**Your Ref: 2024/0122
Our Ref: A000951**

15th March 2024

Land north of Hemingfield Road, Hemingfield, Barnsley - Outline planning application for demolition of existing structures and erection of residential dwellings with associated infrastructure and open space. All matters reserved apart from access into the site

| PROJECT NO: 2344 | DRAWING NO: 2344:01 | REVISION: C | |

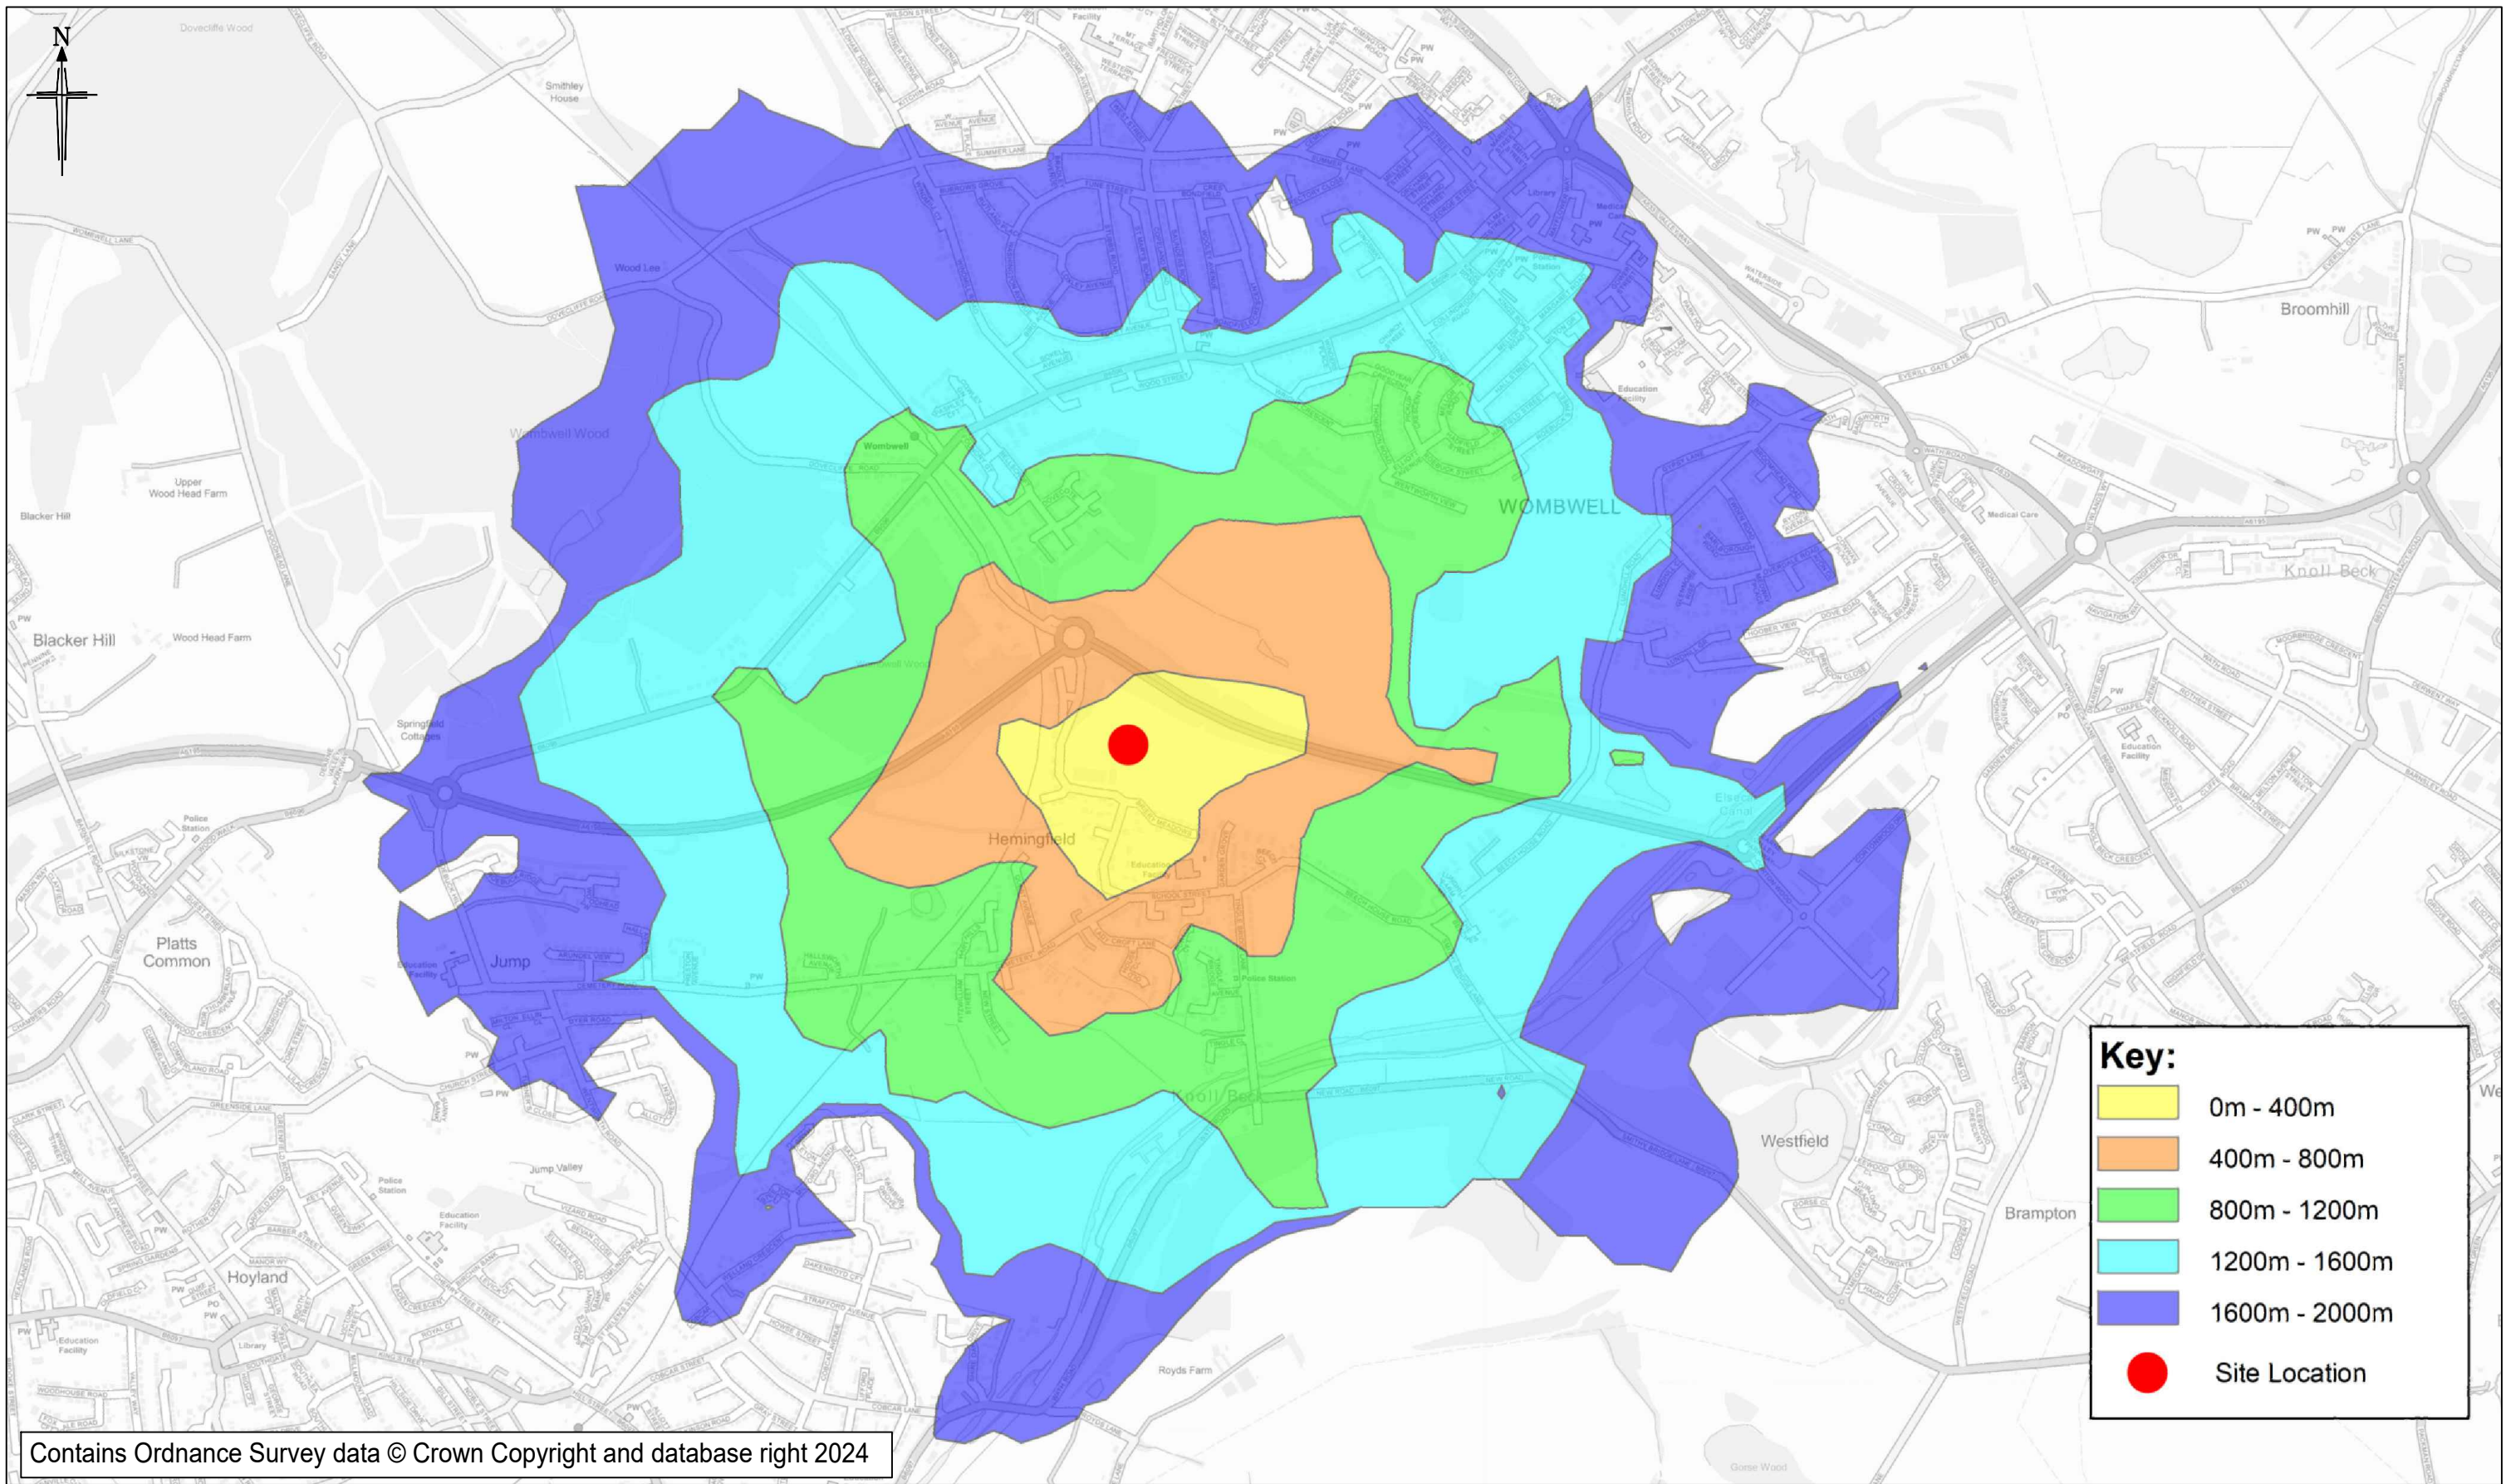
2.) The layout and landscaping details submitted on drawing 'Illustrative Masterplan' 2344.01 (revision C) dated December 2023 that has been prepared by Sten, require amendments, but if planning permission is granted, the matter can be dealt with via condition. The following point(s) should be addressed:

- a.) the submitted drawing appears to show new tree planting within 5 metres and over the public sewer network.
- b.) the submitted drawing should show the site-surveyed position of the public sewer crossing the site
- c.) the submitted drawing should show the required building, and tree planting stand-off from public sewer -- or an agreed alternative scheme
